20240136.5/0808A/R0/WY

**2-4 Burleigh St & 20-24 Railway Parade, Burwood - Acoustic Response to Submission**

This letter has been prepared to respond to Department of Planning, Housing and Infrastructure (DPHI) request for information relating to the development application at 2-4 Burleigh St & 20-24 Railway Parade, Burwood (*Ref: SSD-77260958*, dated 20<sup>th</sup> June 2025).

DRAWING TITLE:
FACADE CONCEPT SECTIONS

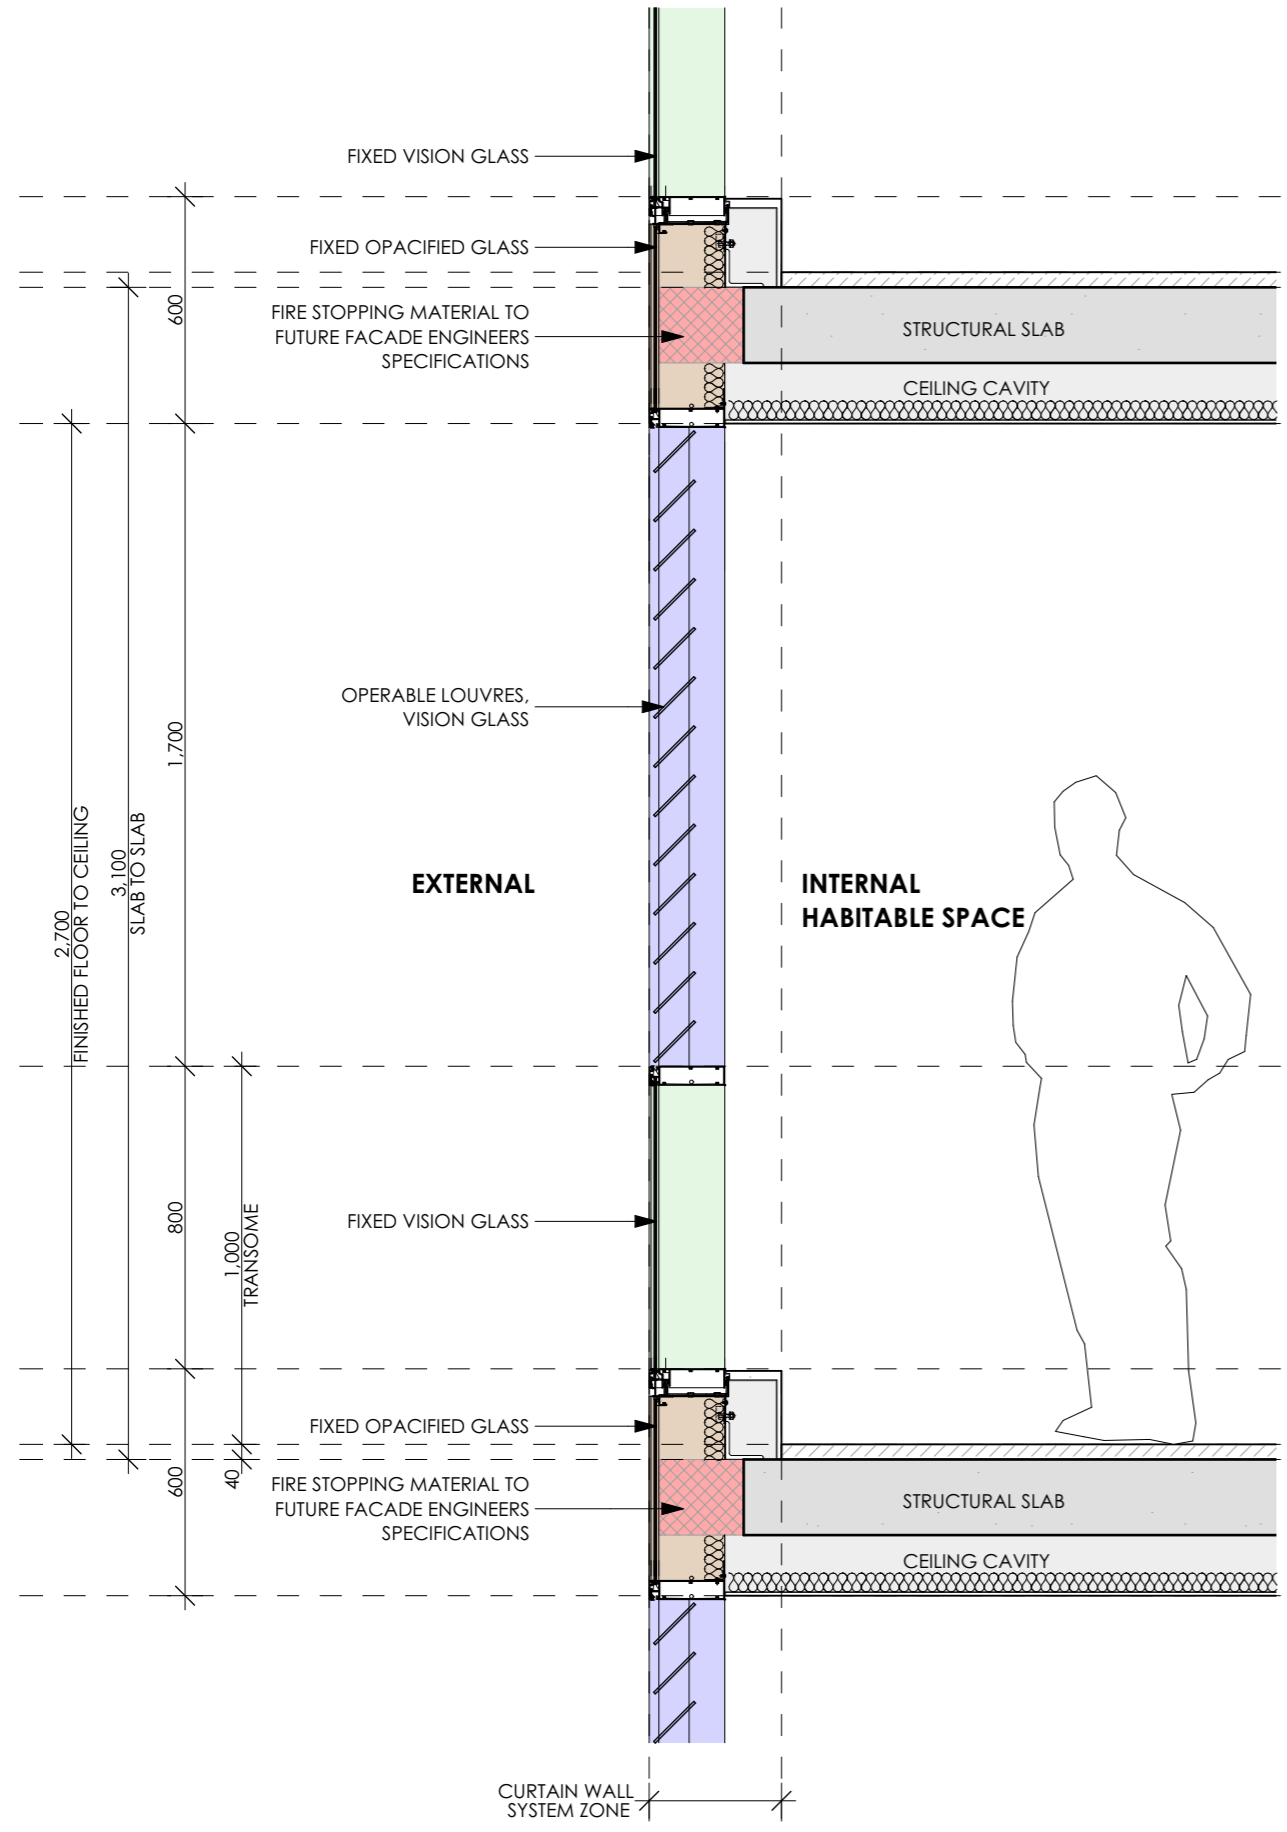
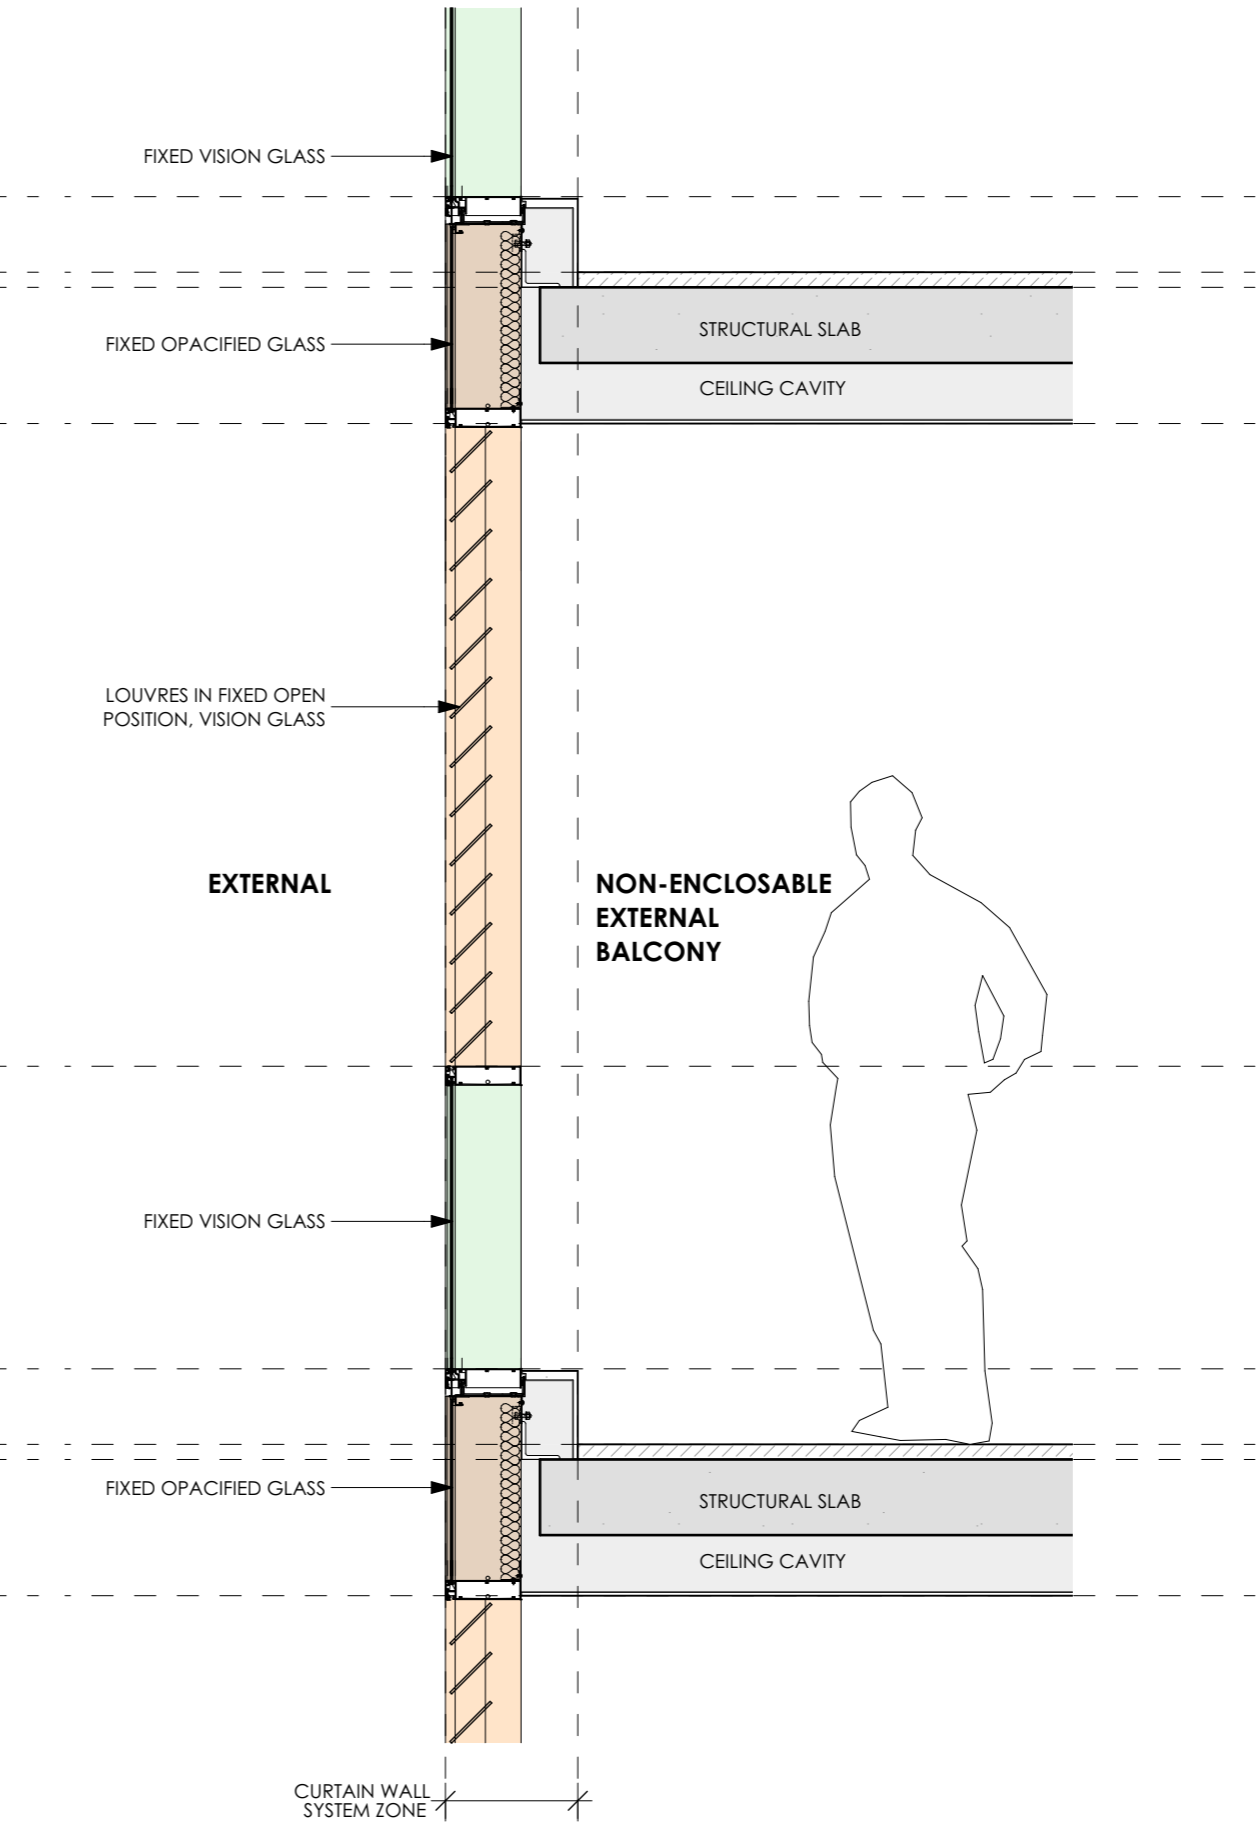
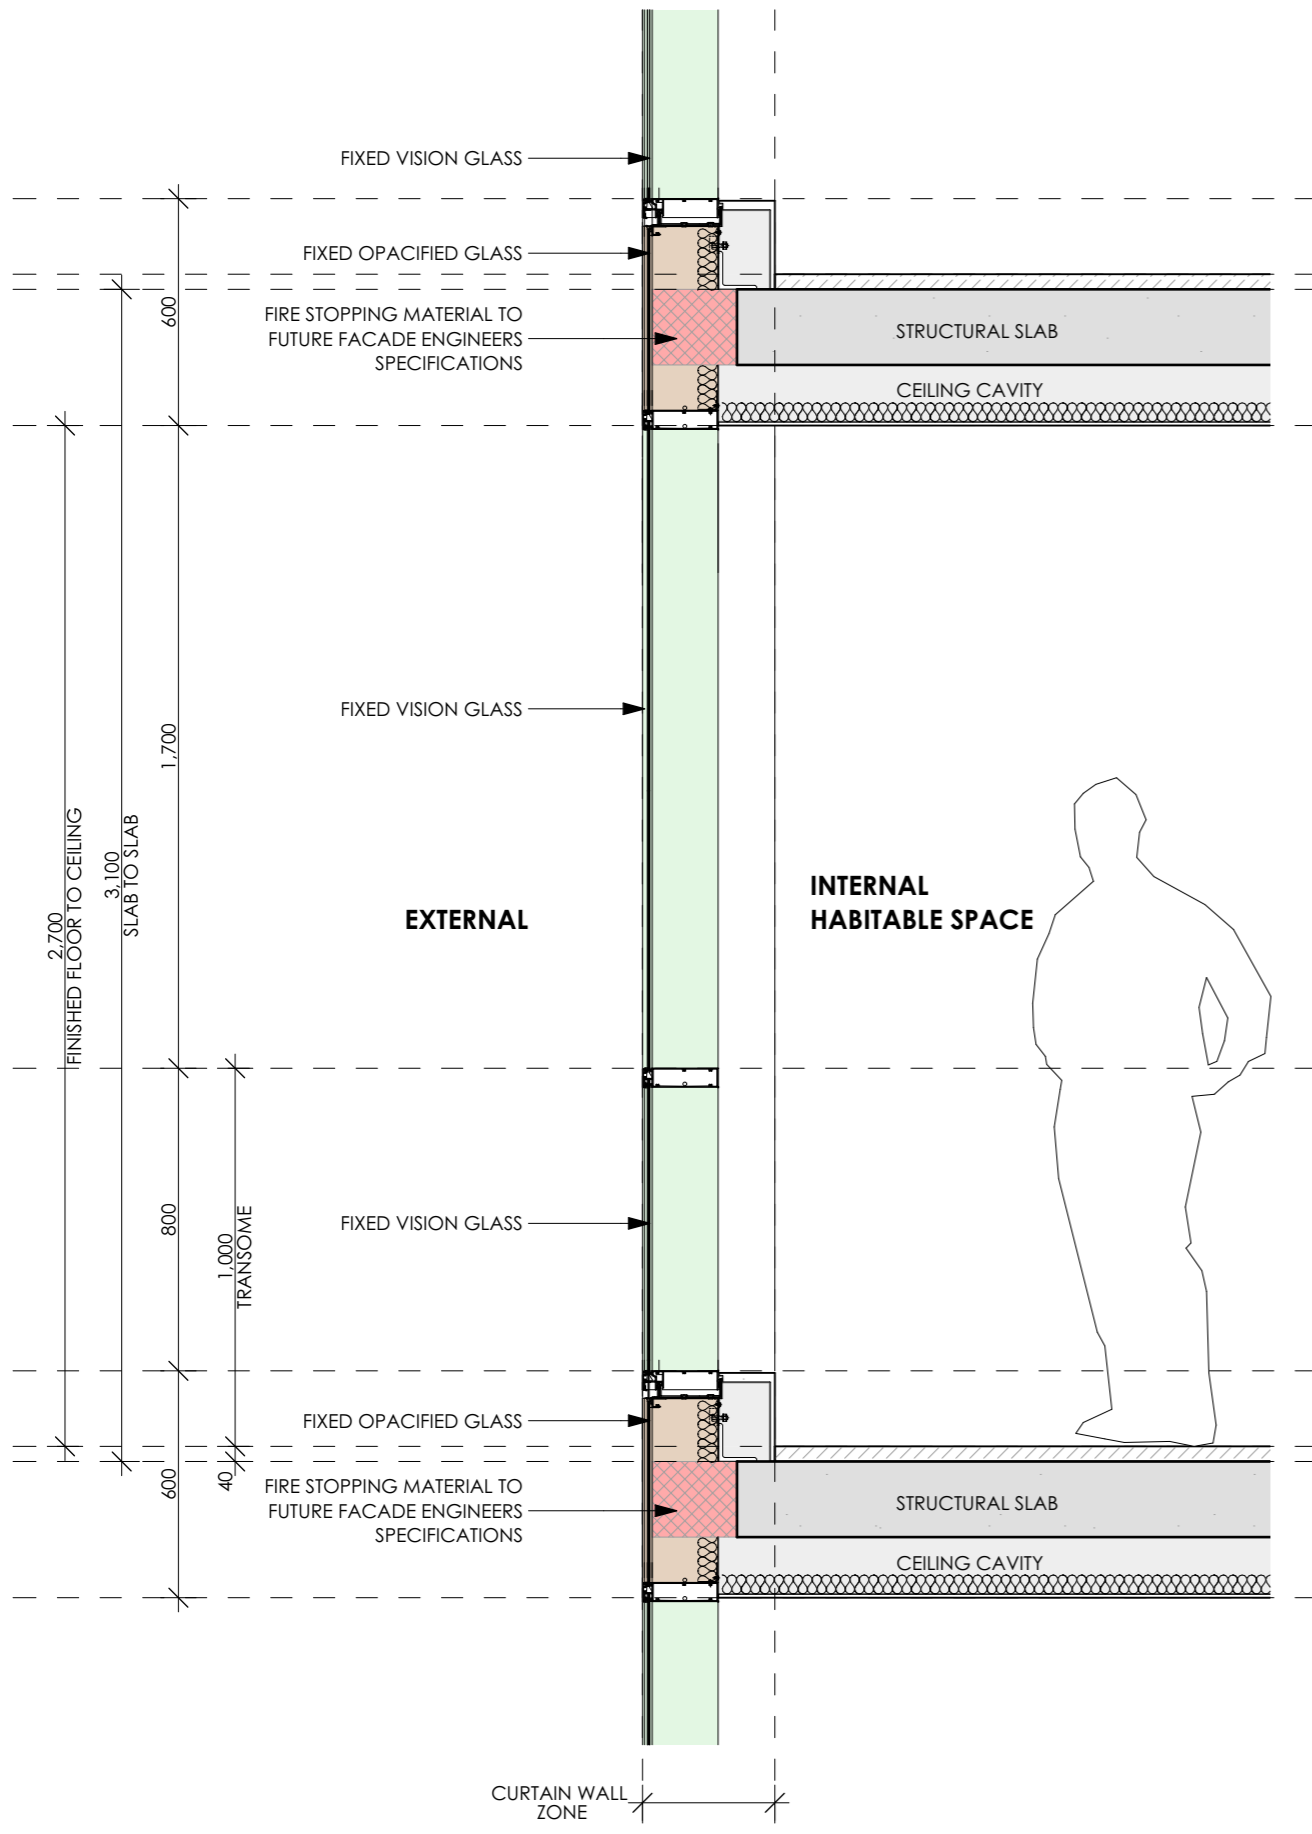
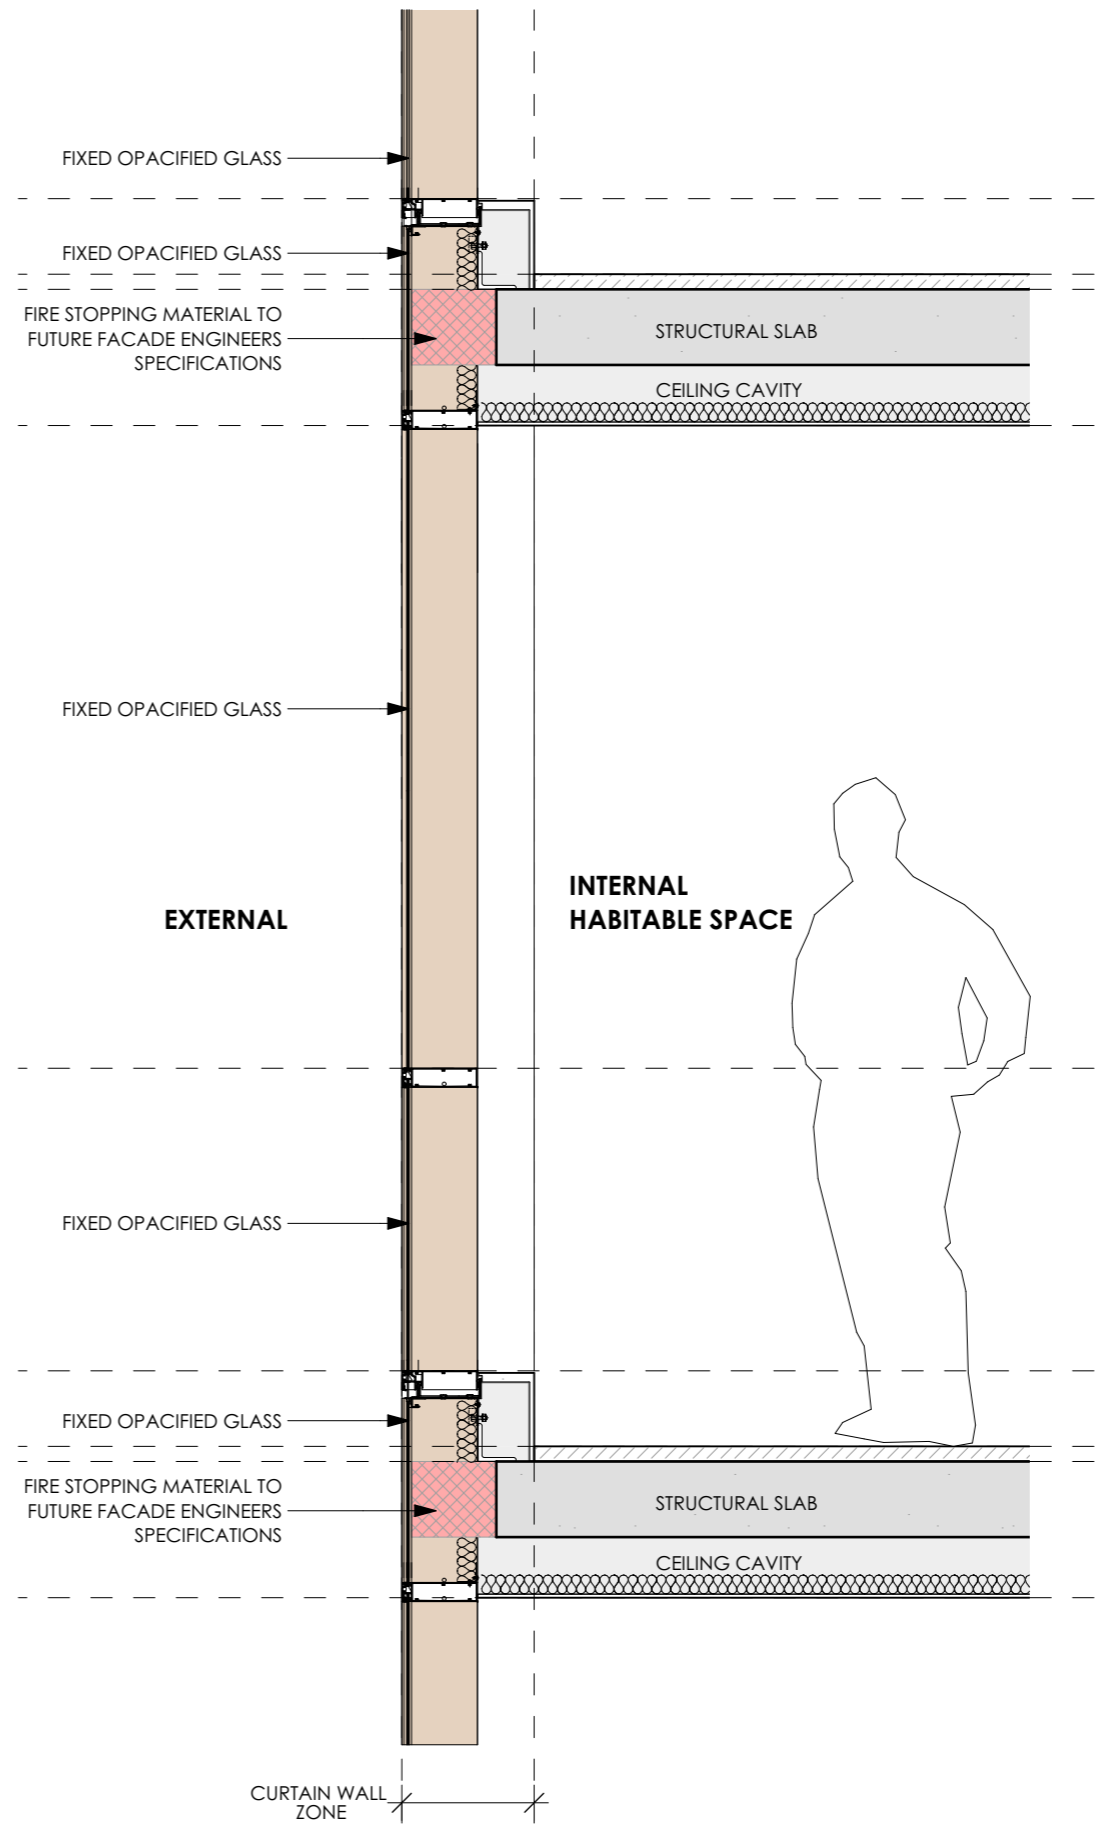
d. Provides updated recommendations, if necessary, noting that the proposed curtain wall external façade appears to be inconsistent with the recommendation at section 9.1.3 that external walls be constructed of precast concrete to ensure internal noise levels.	Section 9.1.3 has been edited to provide more context for curtain wall treatments which are nominated in the glazing section (9.1.1). A 350mm curtain wall zone has been nominated to be further developed with the façade consultant and curtain wall manufacturer at CC stage.
